Hunter Community Environment Centre

Submission to the Environmental Assessment

Port Waratah Coal Services Terminal 4, Project No. MP10_0215

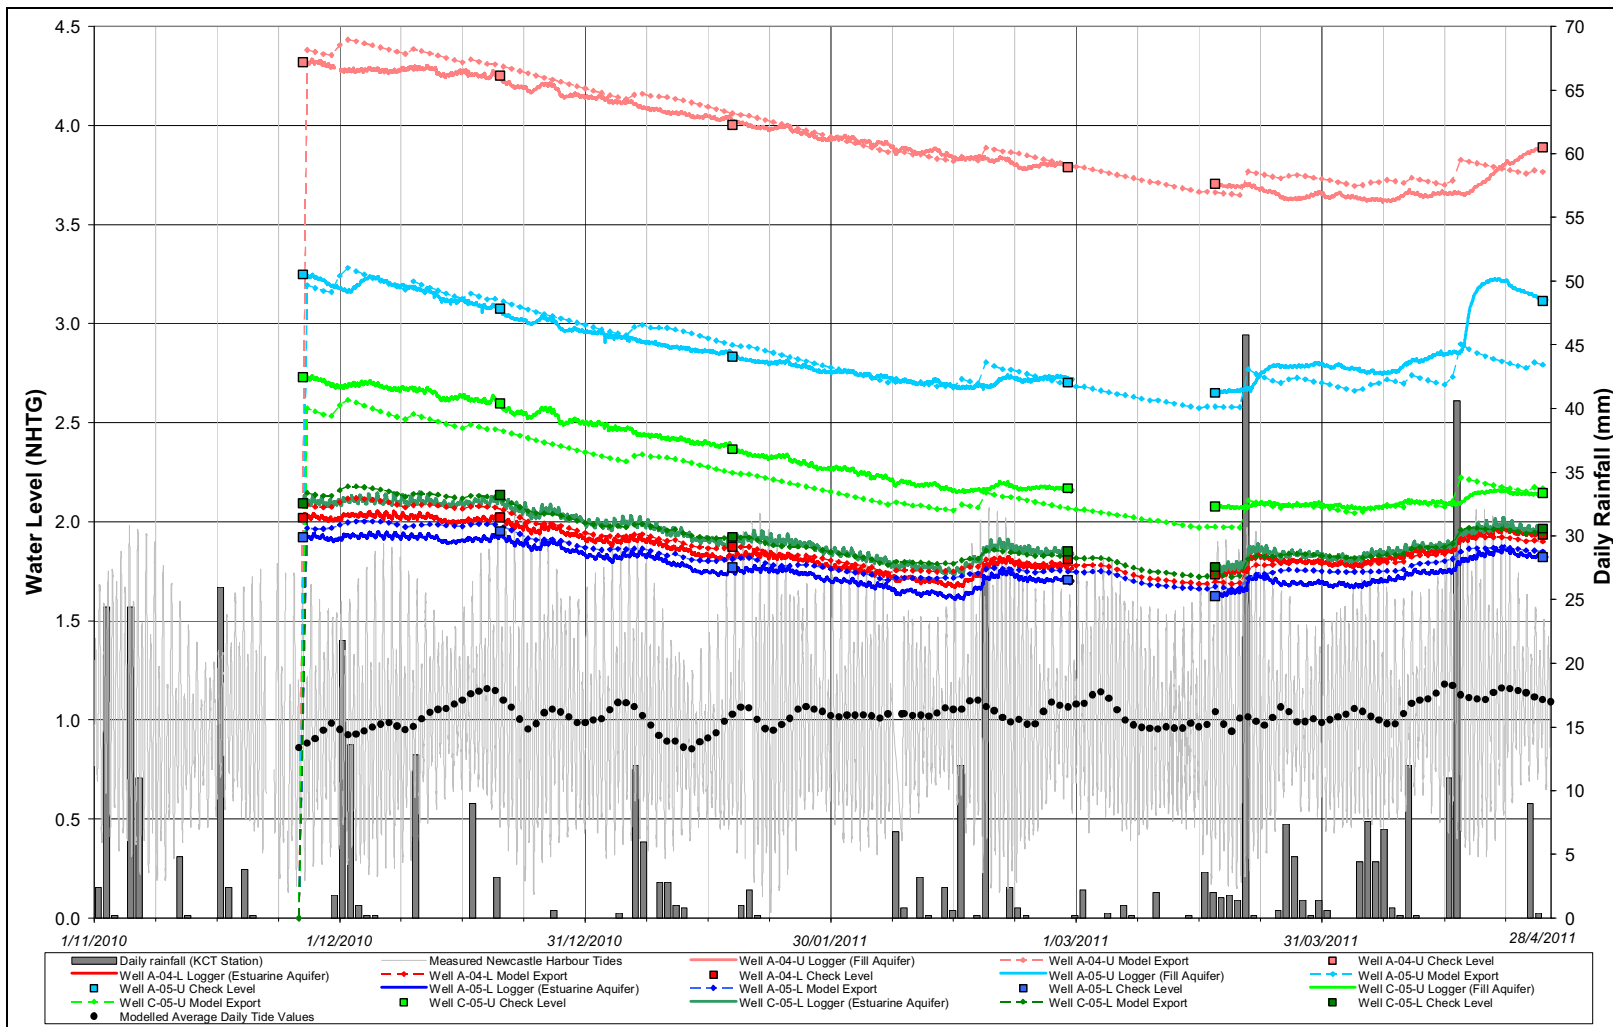
Under the IEA 'new policies' scenario total coal exports (coking and steaming) from Australia will peak at 310MT/yr around 2020 and then decline to 300 MT/yr by 2035 (see p438 World Energy Outlook 2011 and figure 11.24 reproduced below). As discussed above, by 2015 there will already be over 500 Mt/yr of coal port export capacity in Australia. The Terminal 4 proposal is therefore not needed and even if stage 1 of T4 is built, the capacity levels for stages 2 and 3 would not be triggered under any energy supply-demand path remotely similar to the one modelled for the IEA 'new policies' scenario. In such a case stage 1 of T4, if built, will be a high risk of becoming a stranded asset.
